THE CHURCH
OF ENGLAND
THE DIOCESE OF
GUILDFORD

Re:- Planning Application P/10/11
128 Pagham Road, Pagham, Bognor Regis.

The application is for a two storey extension to the side of No 128 up to the boundary with our property No 126.

SIDE ELEVATION - SOUTH

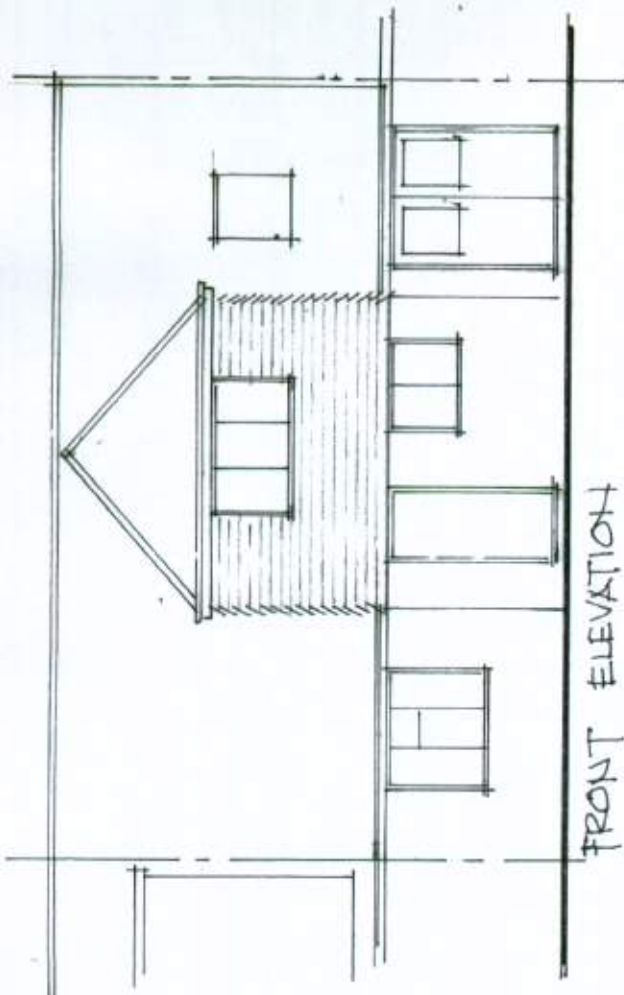
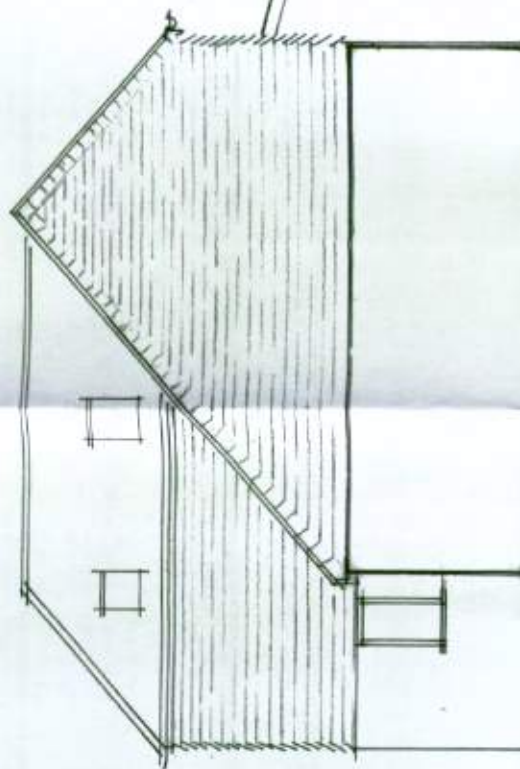
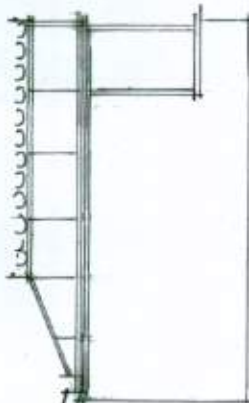
The existing first floor elevation facing my property is plain white painted masonry and as such reflects light well and keeps the stair window of my property well lit with natural daylight. (incidentally there is also a stair window in the flank wall of No128 which is not shown on their drawings) The proposed wall of the extension, which will be much closer, is shown to be in dark tile hanging and shown to extend up vertically to a new gable end to the roof, also tile hung. The existing roof has a hipped end, not a gable end.

I feel this is totally unreasonable to build such a dark wall so close to my boundary and to be so high. The amount of natural light would be severely restricted to my stair window.

If a wall is to be built so close on the boundary then may I propose that it be either slopping back away from No 126 or at least in a masonry that is painted white, (without a window in of course as it would be on the boundary). Also the proposed roof to be changed to a hipped end roof, thus giving a slope which will allow more light to my stair window.
